RE: Application for – 35 Providence Street
(ID# 2003-0232, CBL#169-A-035)

Thank you for your application for your single family at 35 Providence Street. Upon review, planning has the following comments:

TO: Inspections Department
FROM: Jay Reynolds, Development Review Coordinator
DATE: April 22, 2004
RE: C. of O. for #33 Providence Street
(CBL 169A035) (ID 2003-0232)

PLAN SHOWING A STANDARD BOUNDARY SURVEY MADE FOR MARK FLOURDE

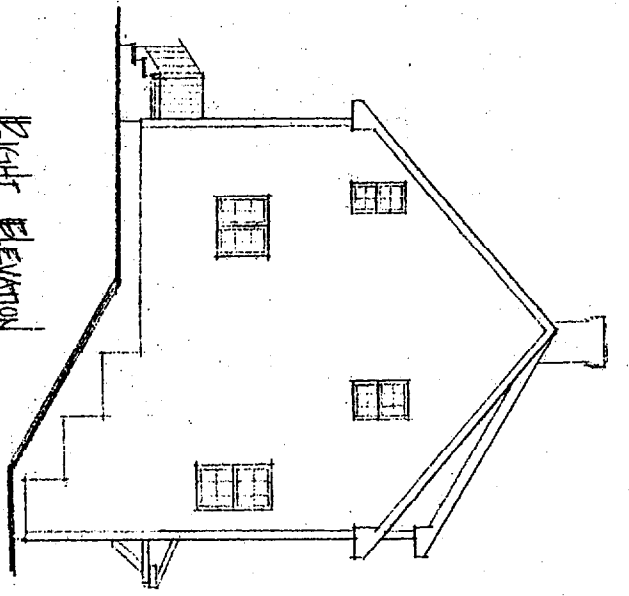
1. Please add a cleanout to the sanitary sewer lead. *Cleanout*
2. Please add two street trees to your site plan, as required for single family development. *Two*
3. The site plan appears to show two driveways/curb cuts. Is this correct? *One Curb Cut...*
